# CITY OF ALBUQUERQUE

**RE: Eisenhower Pool Site Imps.  
11001 Camero Ave NE  
Grading and Drainage Plans  
Engineer's Stamp Date: 08/19/2025  
Hydrology File: E21D007  
Case # HYDR-2025-00310**

Based upon the information provided in your submittal received 8/26/2025, the Grading and Drainage Plans **are not** approved for Grading Permit or Building Permit. The following comments need to be addressed for approval of the above referenced project:

**EISENHOWER POOL  
SITE IMPROVEMENTS**  
11001 CAMERO AVE NE,  
ABQ, NM 87111

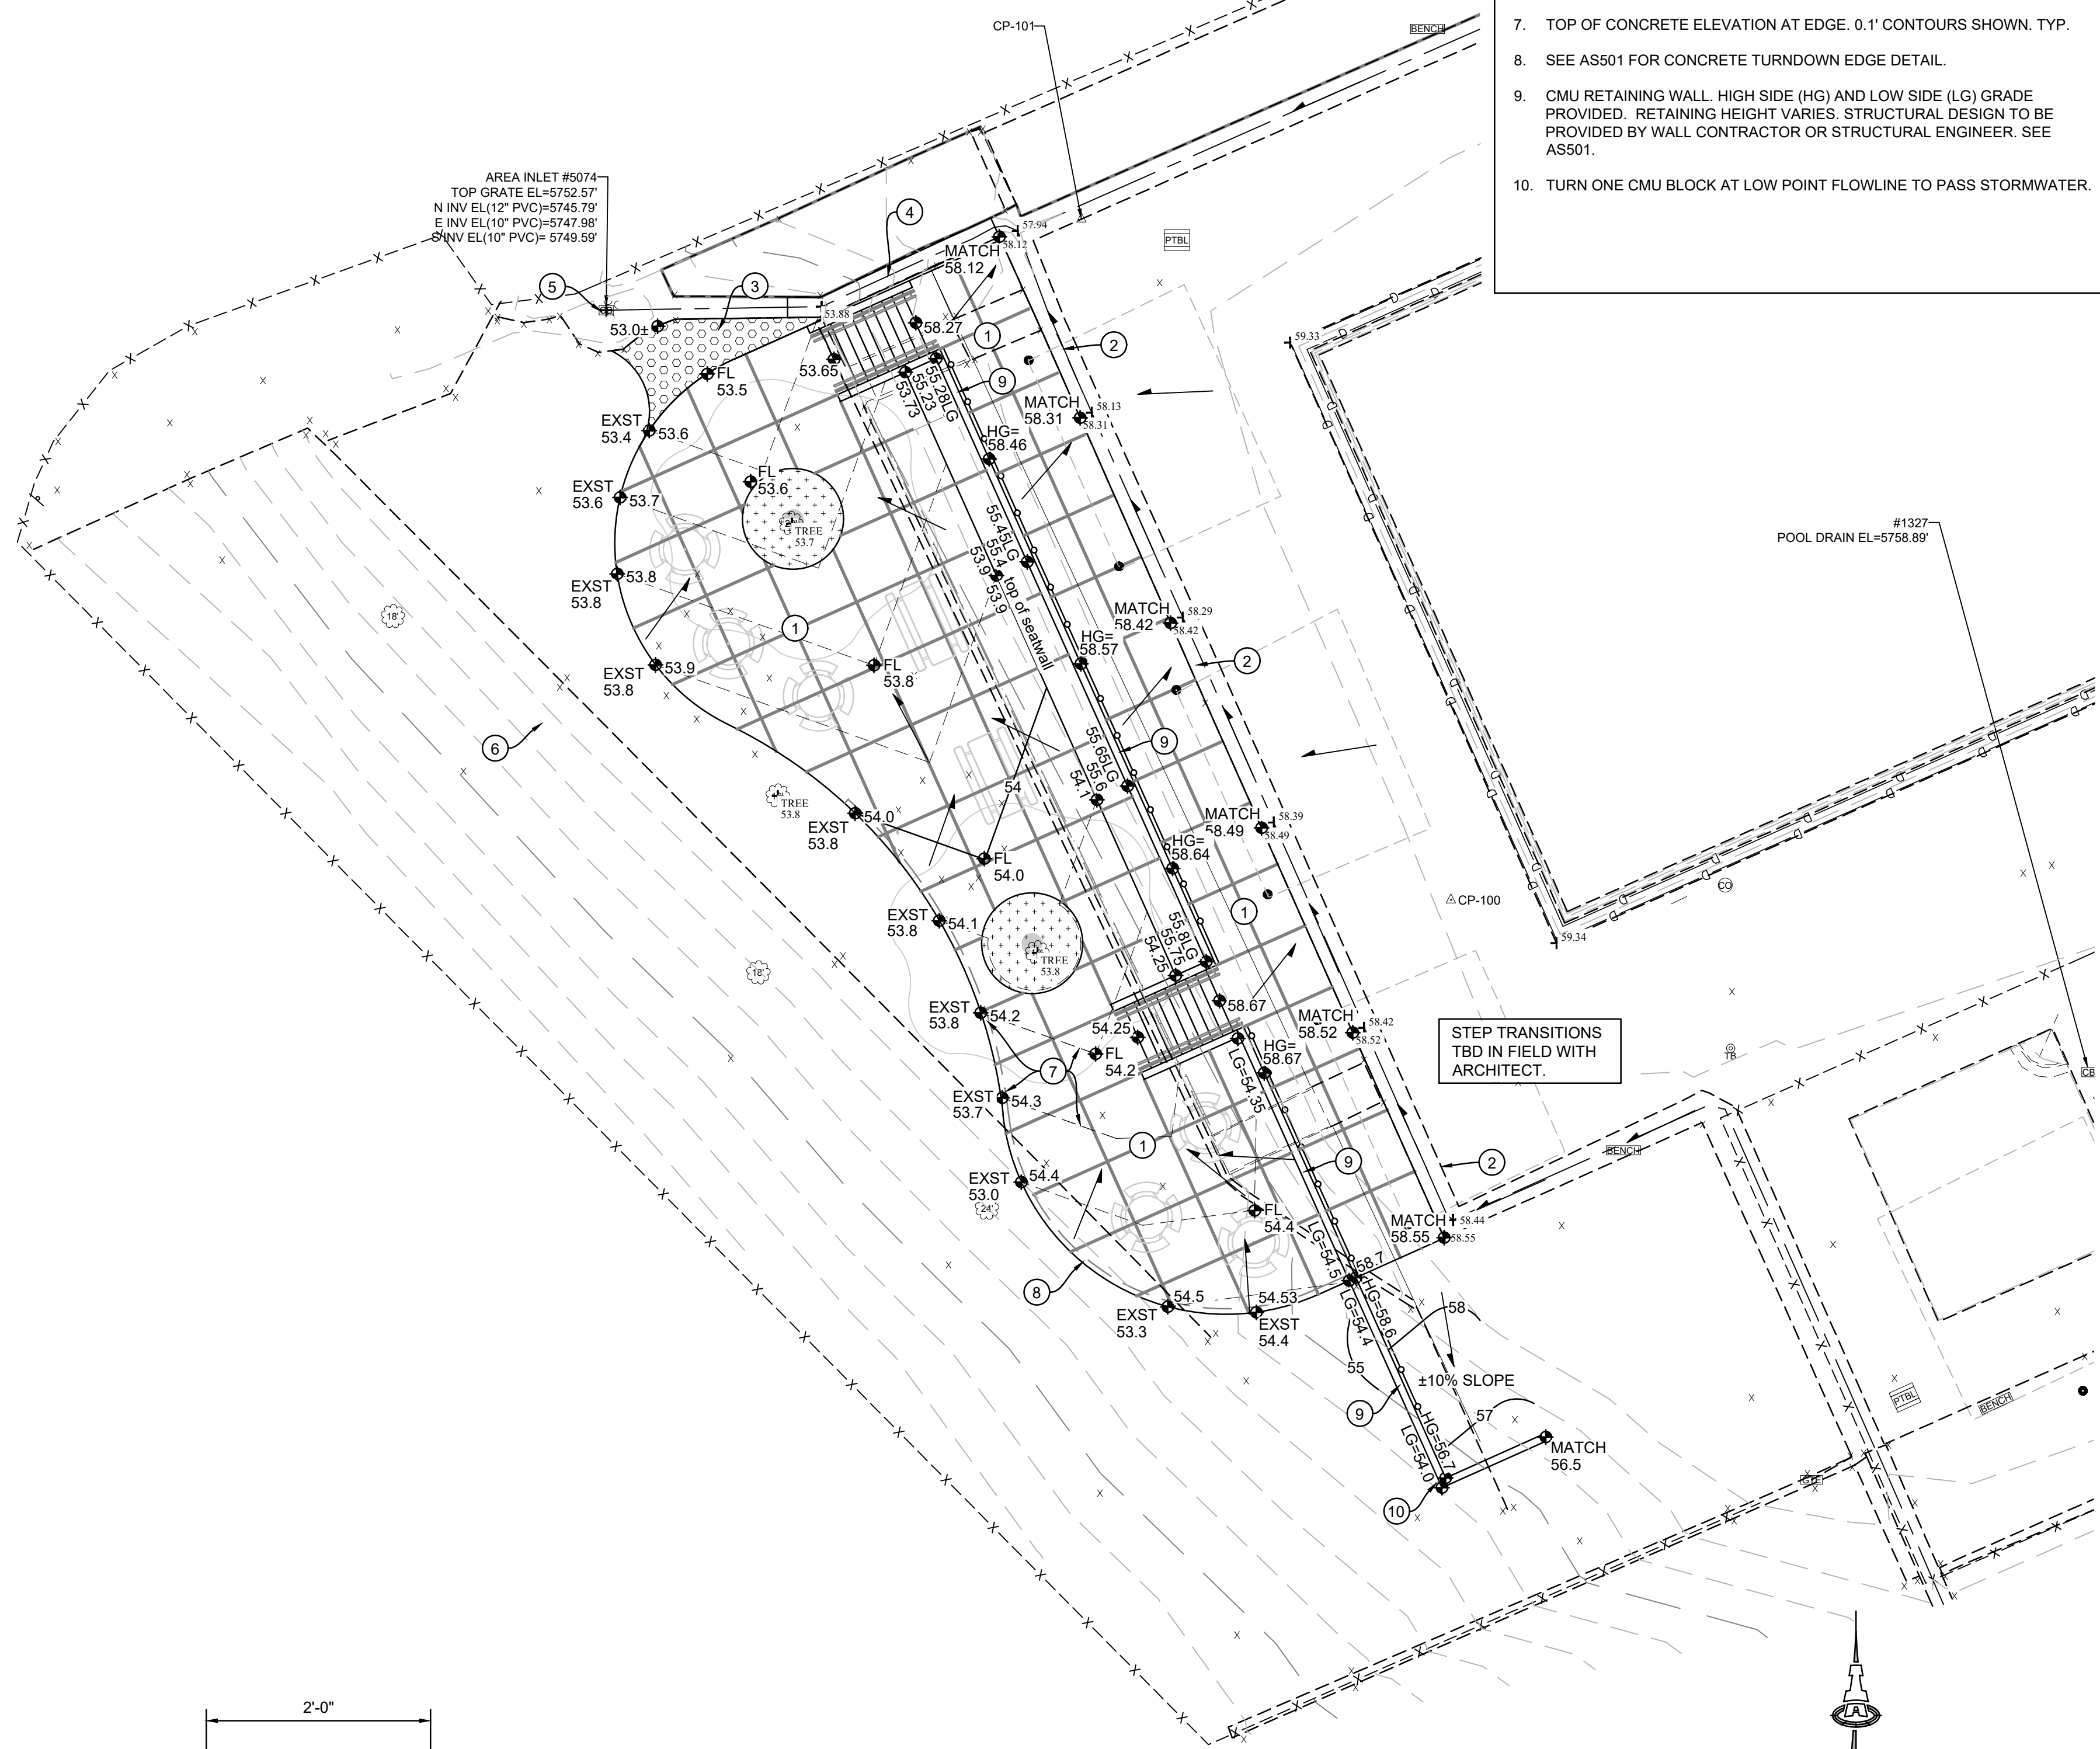
1. Include project benchmark and datum.
2. Please update the FIRM Map for this location. The map does not match the description and is for the wrong location.

**FLOOD HAZARD: PER BERNALILLO COUNTY FIRM MAP #35001C0144G DATED 9/26/2008, THE SITE IS LOCATED WITHIN ZONE "X", DEFINED AS AREAS DETERMINED TO BE OUTSIDE THE 500-YEAR FLOODPLAIN.**

3. The plan needs to show that the Detention Pond that is to be used as the outfall will have sufficient volume to sustain the proposed development or state what improvements are required. Please show the drainage area that goes to this pond to verify that the size is adequate with calculations.
4. Since an existing pond is to be used, please state the existing condition and if there will be any maintenance needed to bring it into compliance with soil stabilization, erosion control, and/or any other requirements per the DPM for its intended use and function.

5. Please provide a map showing the exact location of the site. The school is a 19-acre site and this project is disturbing 0.12-acres. It's difficult to determine where this site is given the information provided.
